CITY OF ALBUQUERQUE

**RE: South Las Altos Children's Park
Grading and Drainage Plan
Engineers Stamp Date 12/9/15 (K20D062)**

**RE: South Los Altos Children's Park
Grading & Drainage Plans
Engineer's Stamp Date 8-04-2015 (File: K20D062)**

SOUTH LOS ALTOS CHILDREN'S PARK
GRADING AND DRAINAGE PLAN - SOUTH

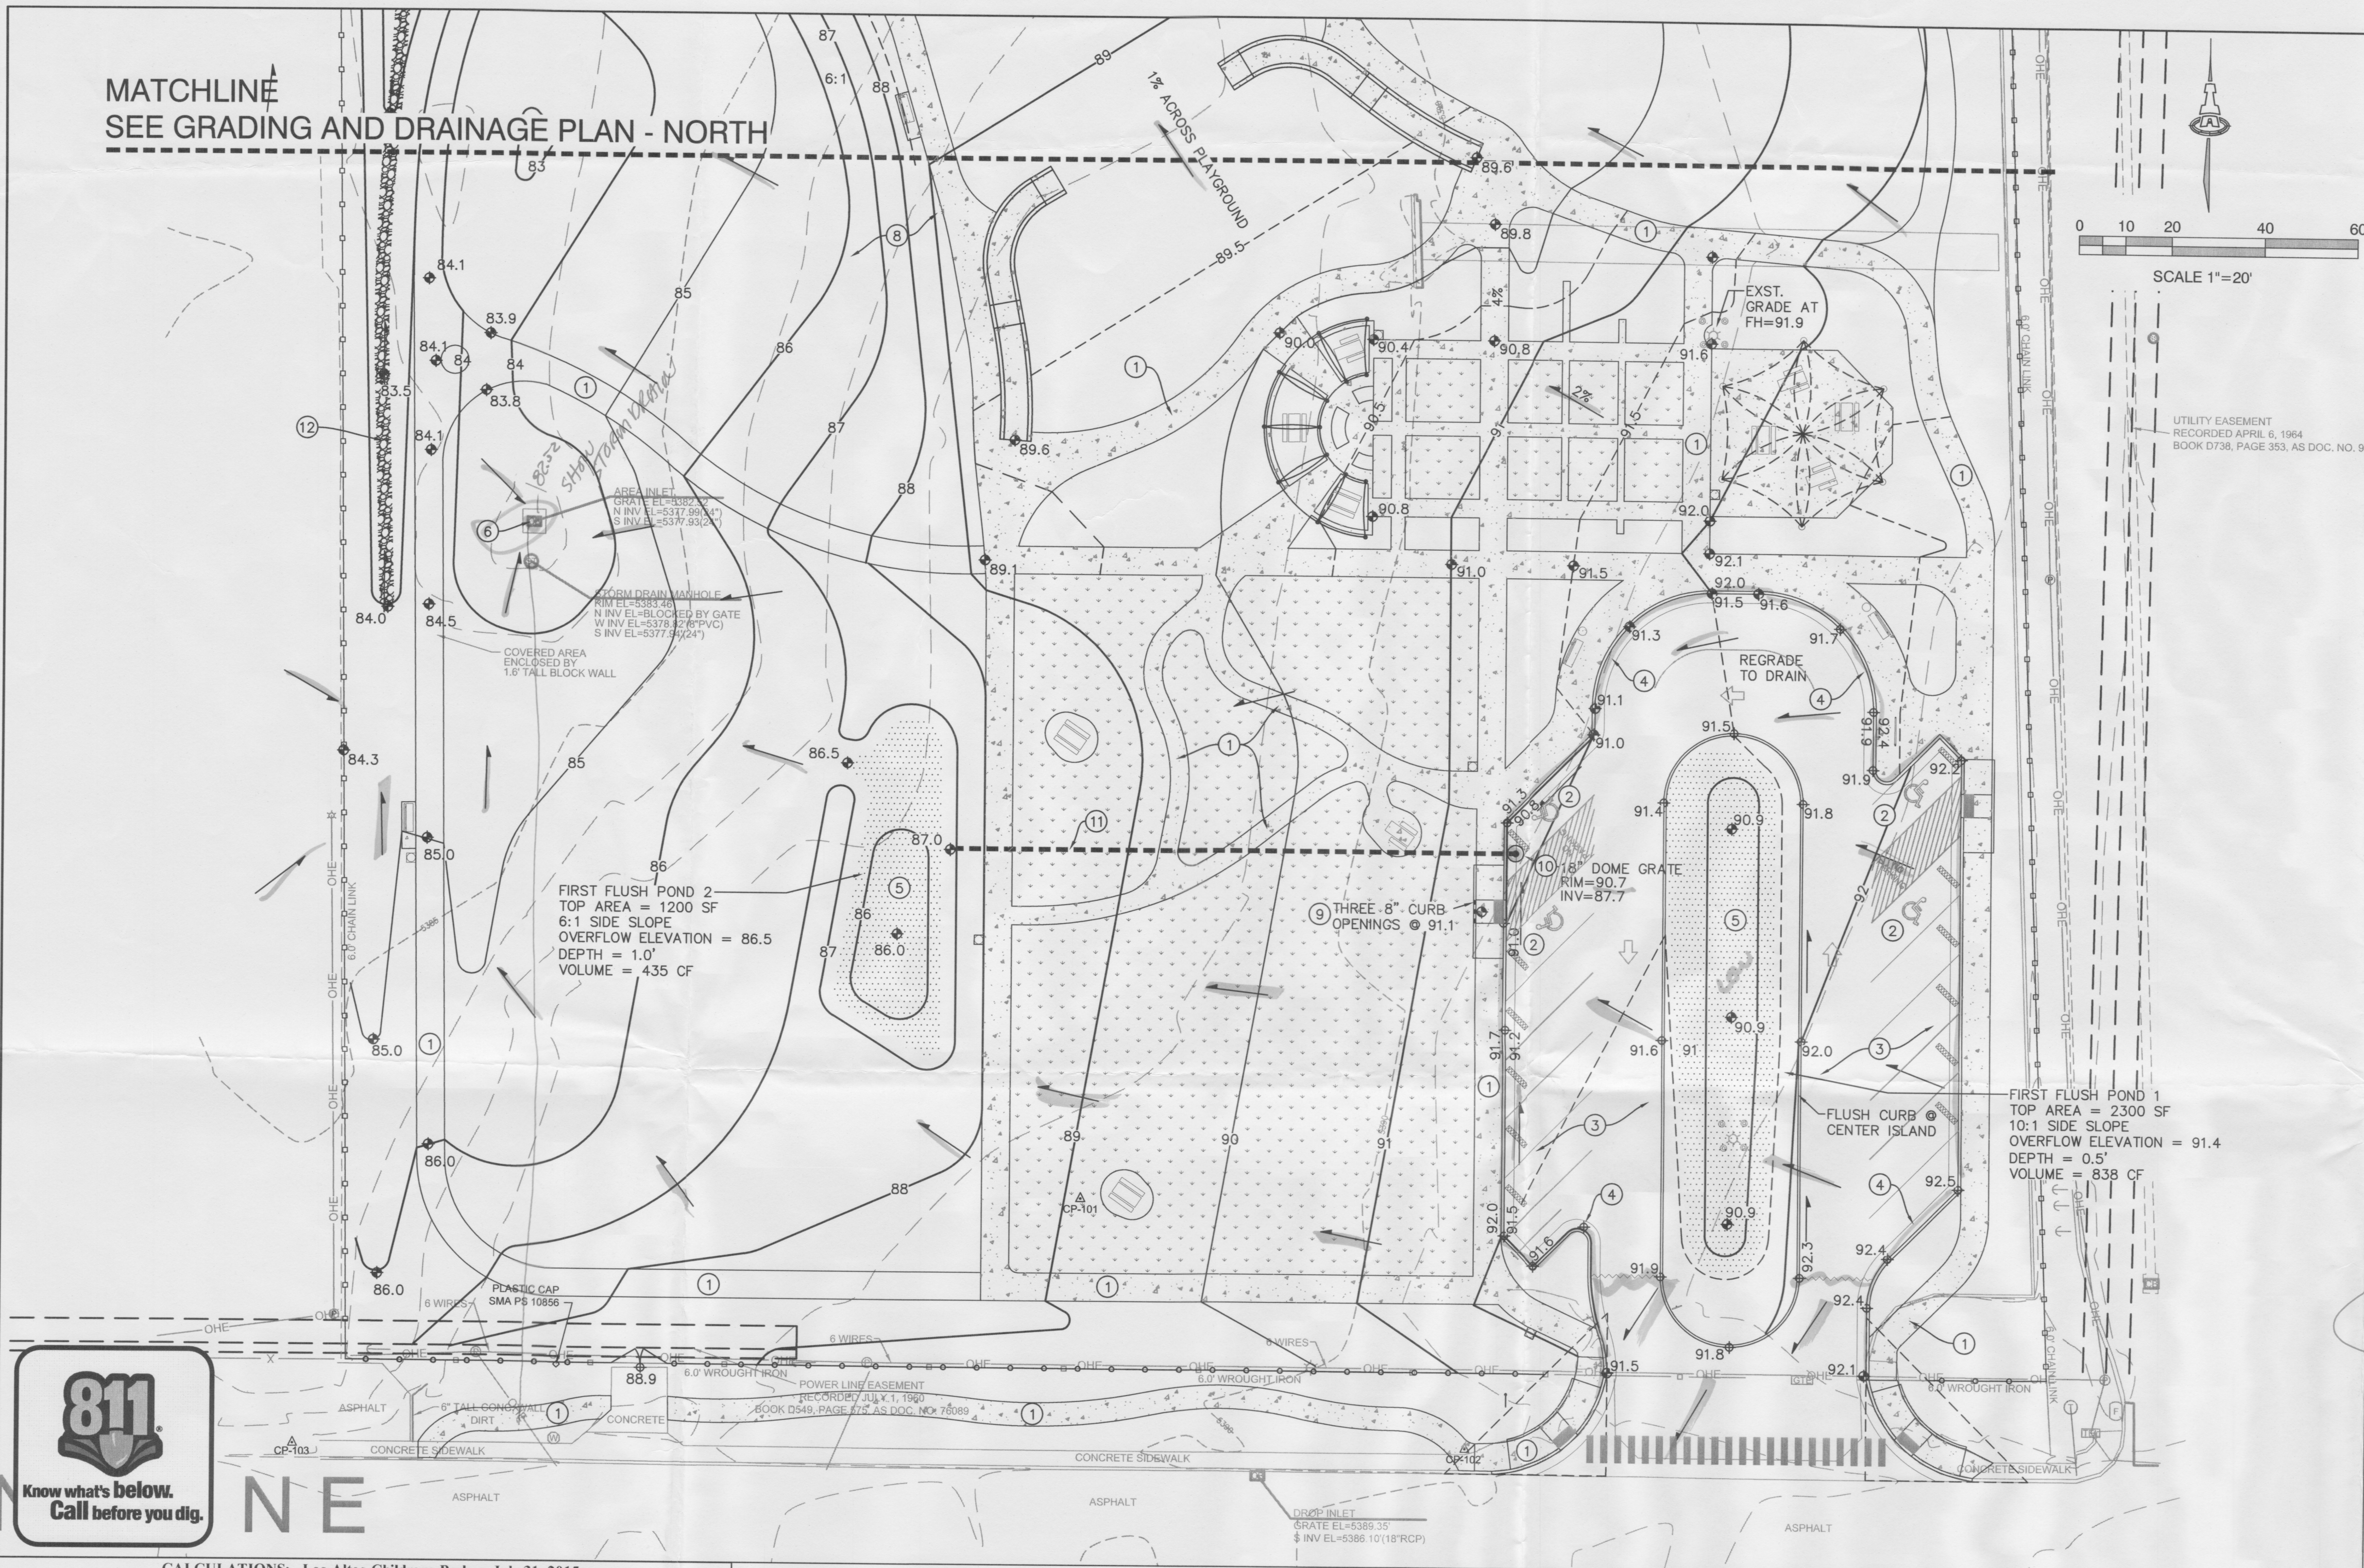
The platting action associated with this site will require a cross-lot drainage easement to accept offsite flows from the west and north. It is noted that flows from the east do not enter this site.

Prior to Grading Permit approval, show the existing storm drain system on the plan.
